**Application by National Highways for an Order
granting Development Consent for the Lower
Thames Crossing (Ref. No. TR010032)**

**Submission for Examination
Deadline 3 – 24 August 2023
(Rule 8 Letter Annex A –
Examination Timetable, item 18)**

**Emergency Services & Safety Partners
Steering Group (ESSP SG)
(IP No. 20035777)**

**Comments on the Applicant's
Comments on WRs Appendix D
([REP2-049](#))**

# Mott Family Emergency Vehicle RVP Location

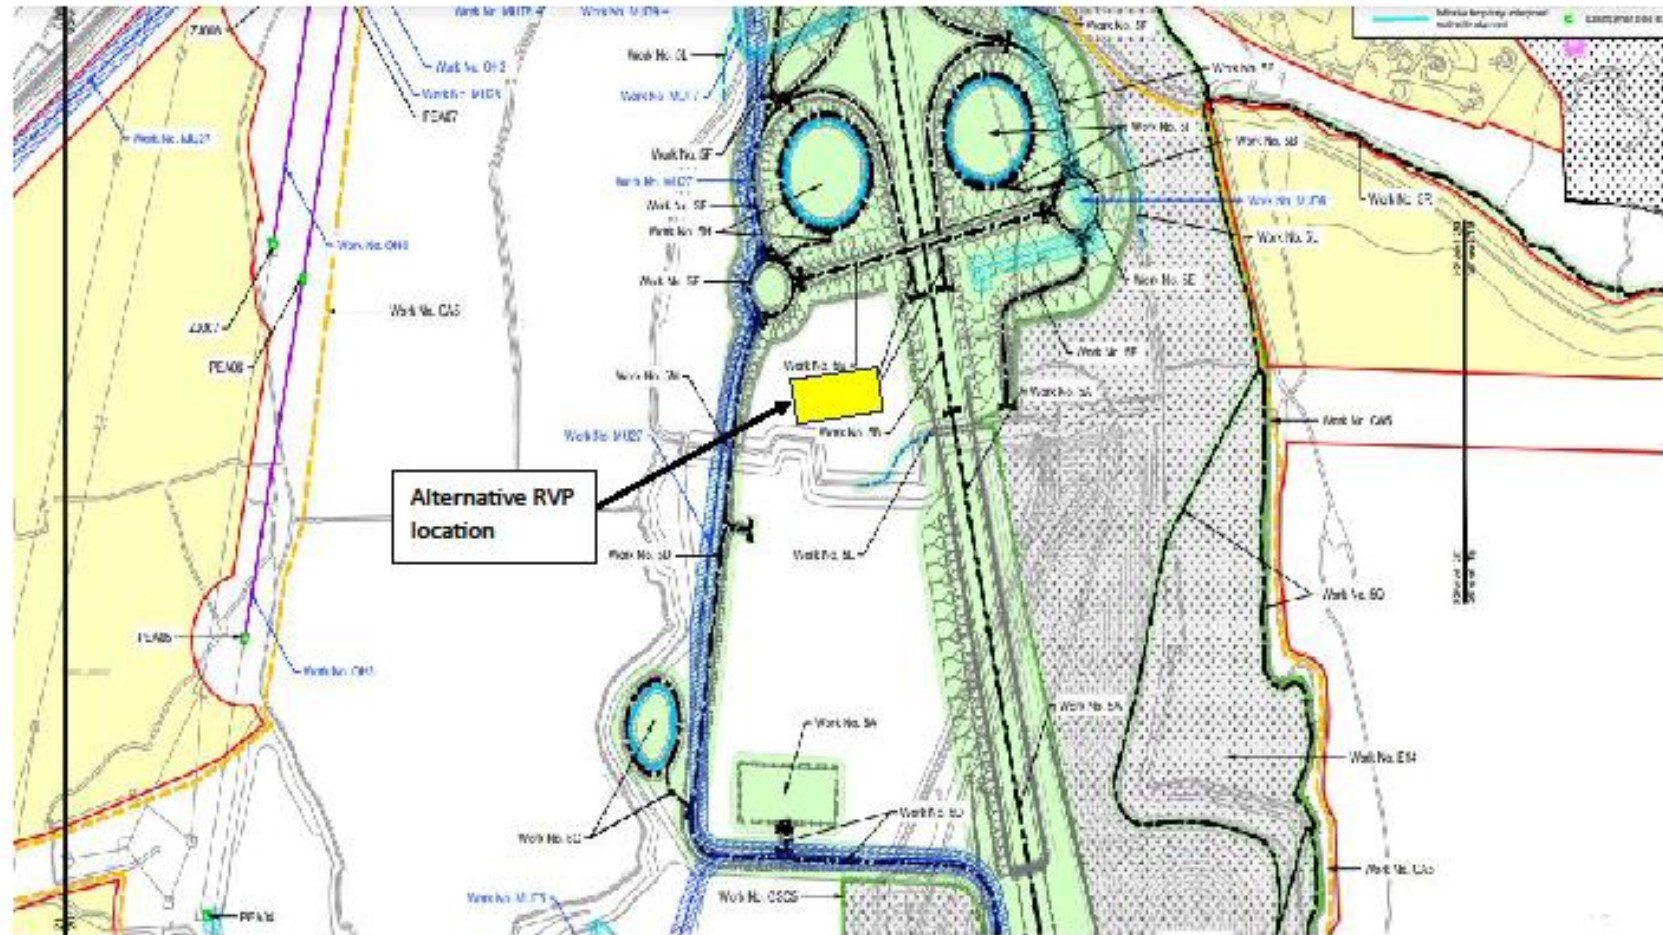
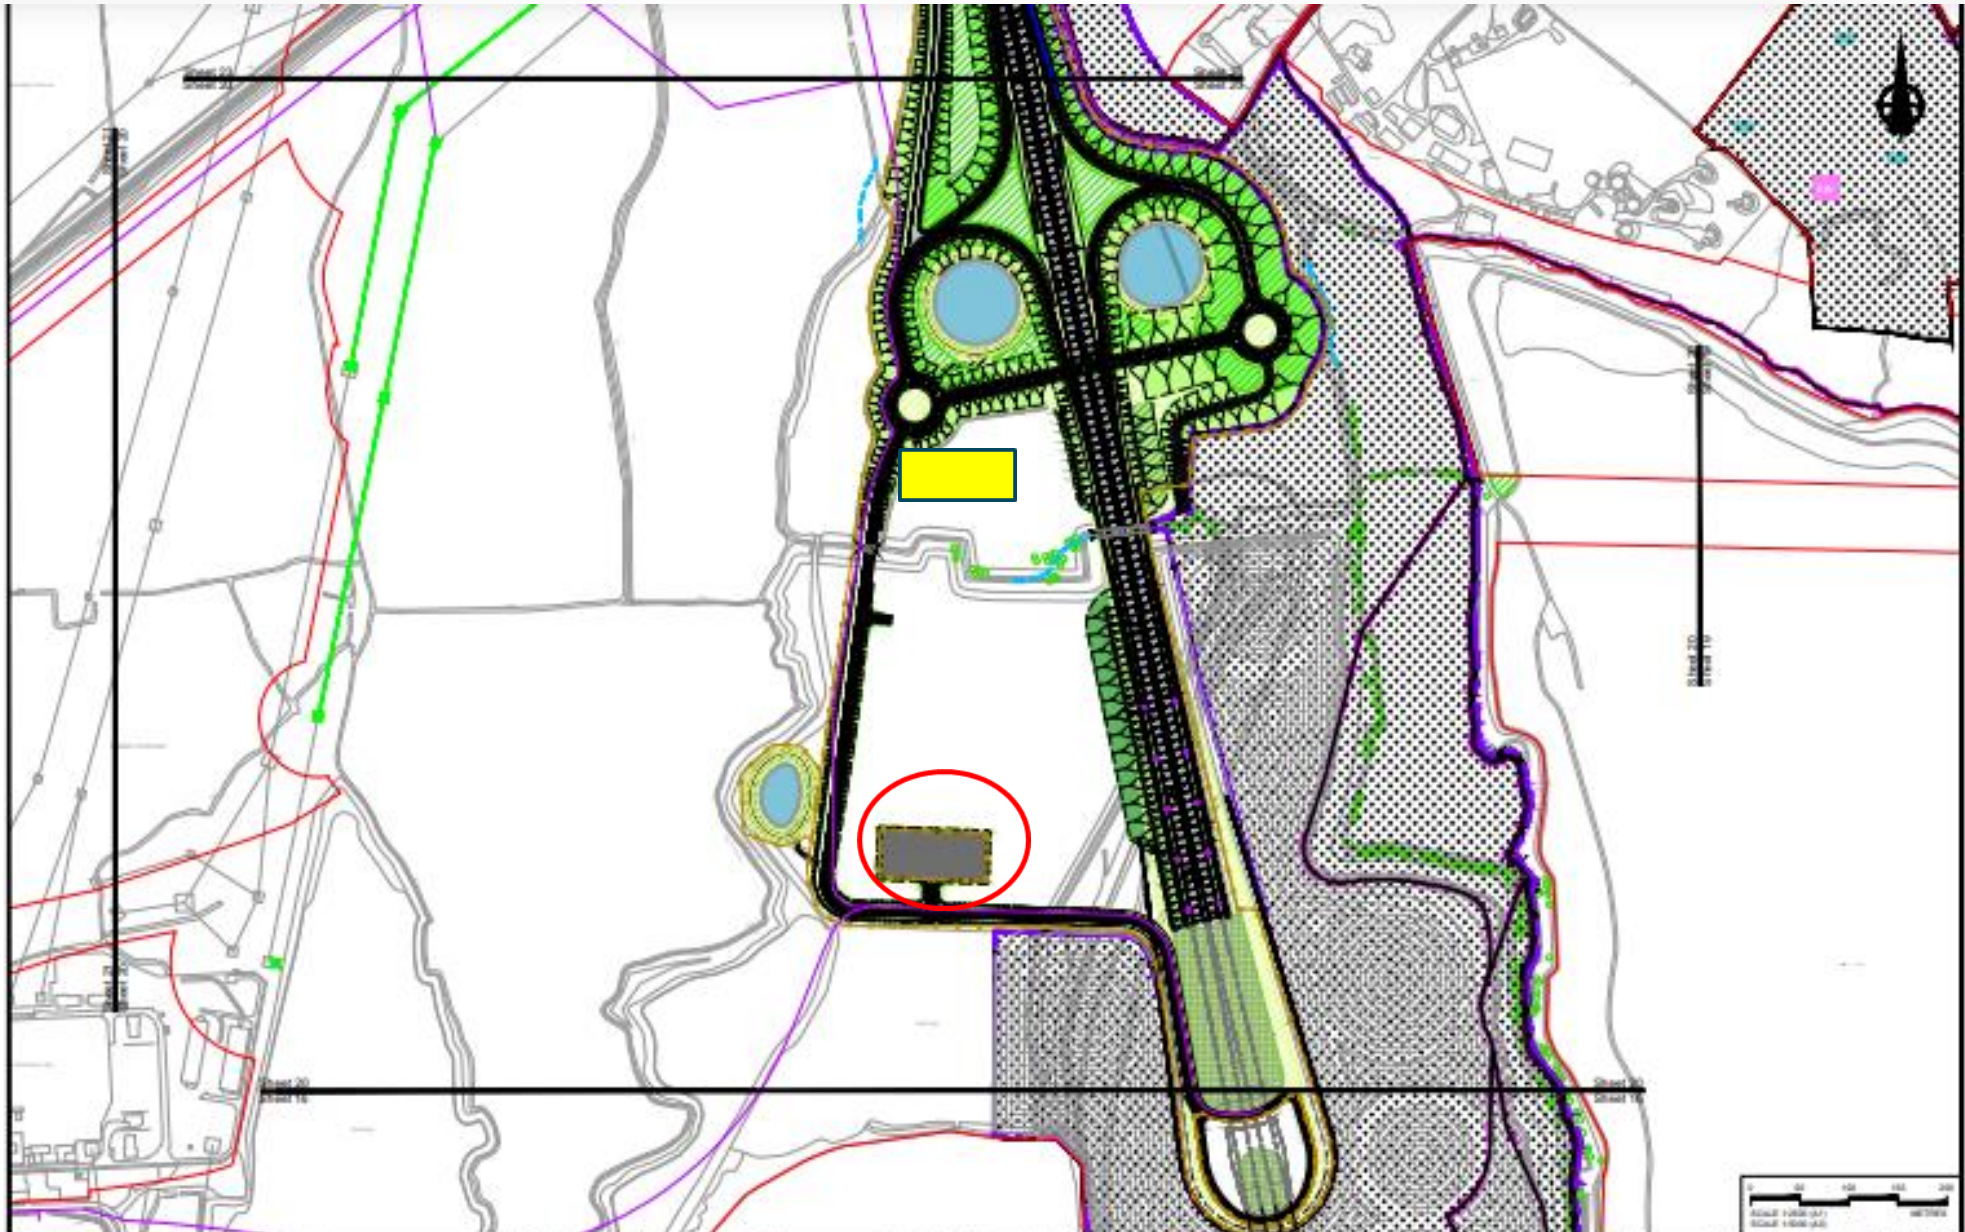
26 - 28	<p>The Applicant has shared information with the ESSP SG setting out the rationale for the selection and location of the RendezVous Point (RVP) at the north tunnel portal, as shown in the scheme preliminary design. However, that explanation is considered by the ESSP SG to not address the key issues, and does not justify the RVP as submitted. The ESSP SG also still has concerns regarding the southern tunnel portal RVP shown in the preliminary scheme design. Although the Applicant’s proposals were discussed with the Applicant at a meeting in January 2022, feedback from the ESSP SG objecting to those proposals was provided on 9 March 2022. Since that time until very recently there has been no further discussion between the parties regarding RVPs.</p> <p>The ESSP SG has arranged further meetings with the Applicant to discuss these points, and welcomes the fact that the Applicant has now taken up the previously made offer to visit an existing RVP at Stansted Airport to inform progress on this matter.</p>
